CITY OF ALBUQUERQUE

December 20, 2012

RE: Mitchell Residence – Grading & Drainage Plan for Building Permit
2939 San Rafael S.E. P.E. Stamp 12/17/12 ~ File: **L16-D026**

Grading & Utility Plan

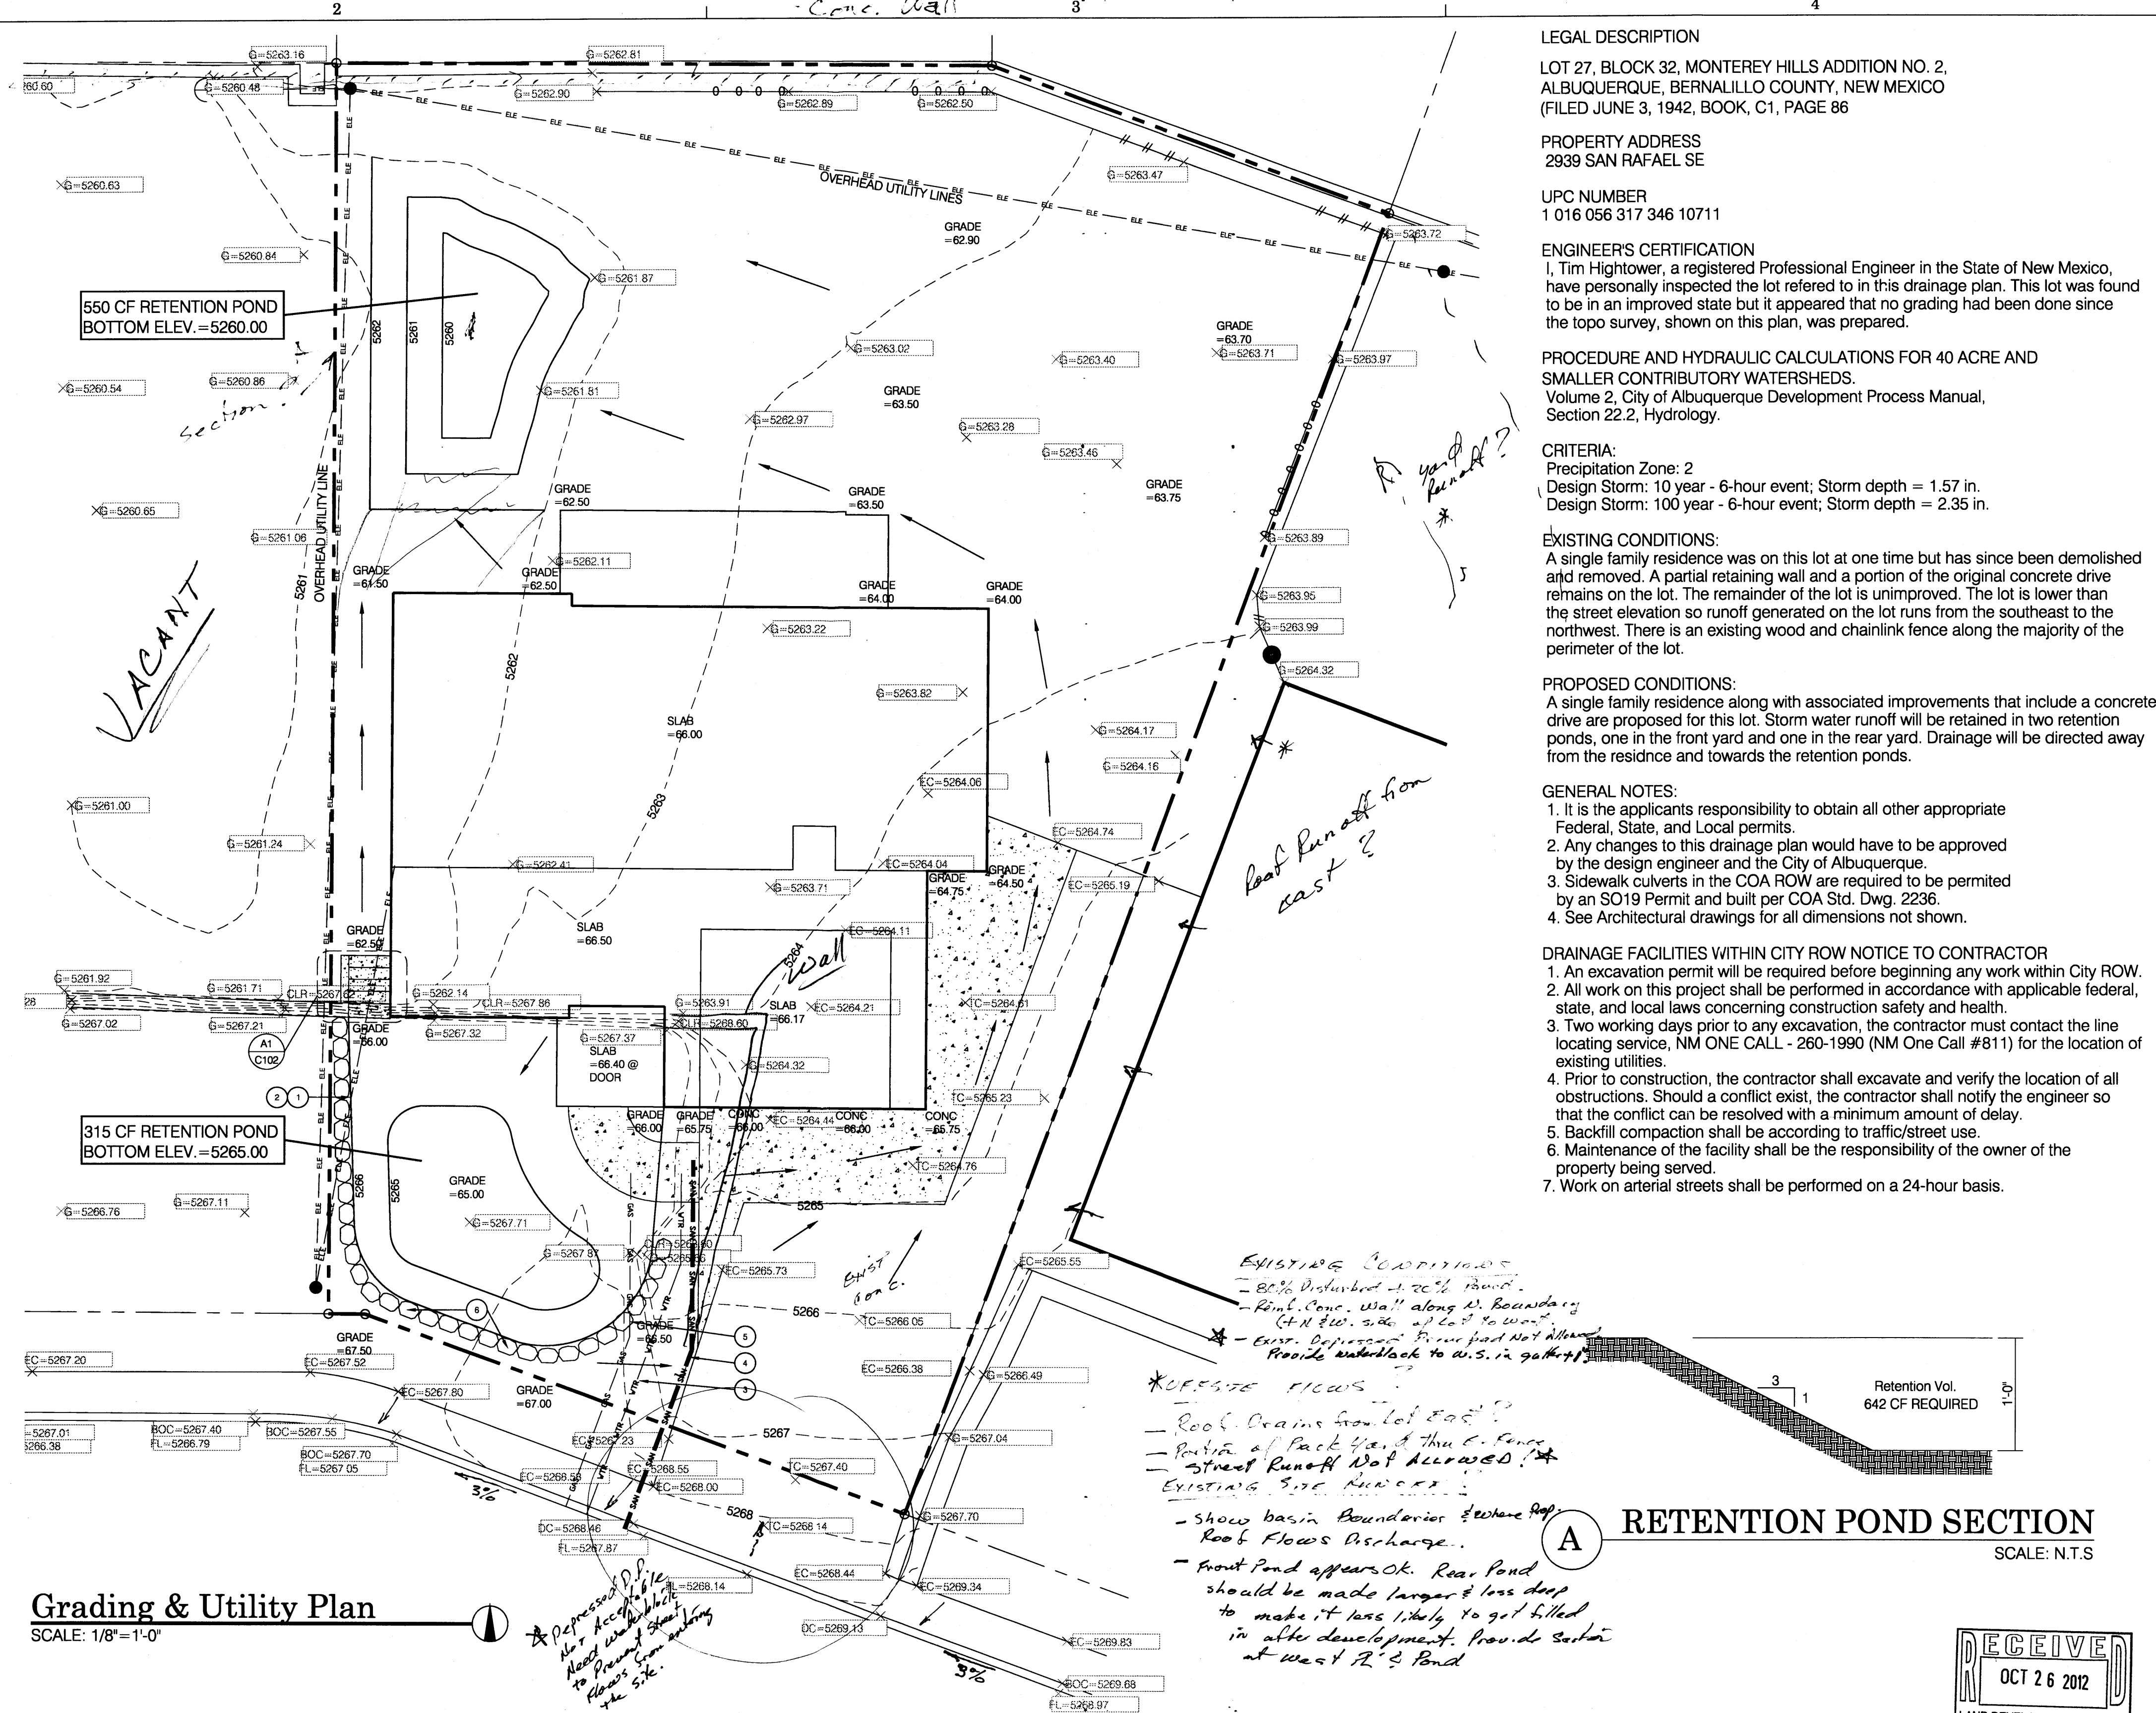
After reviewing your drainage basin clarifications on the above referenced plan it appears the pond volume will be more than adequate to detain flows from the property. As discussed with our staff, the rip rap emergency overflow channel can be omitted from the plan, and overflow from the backyard pond can continue to sheet flow as it did historically in the event that water were to overtop the pond. Please note this deletion on the As-Built Grading Certification Plan.

If a future garden wall is constructed at the western edge of the ponding area, the design should include turned blocks or openings to allow for the pond to overflow as designed.
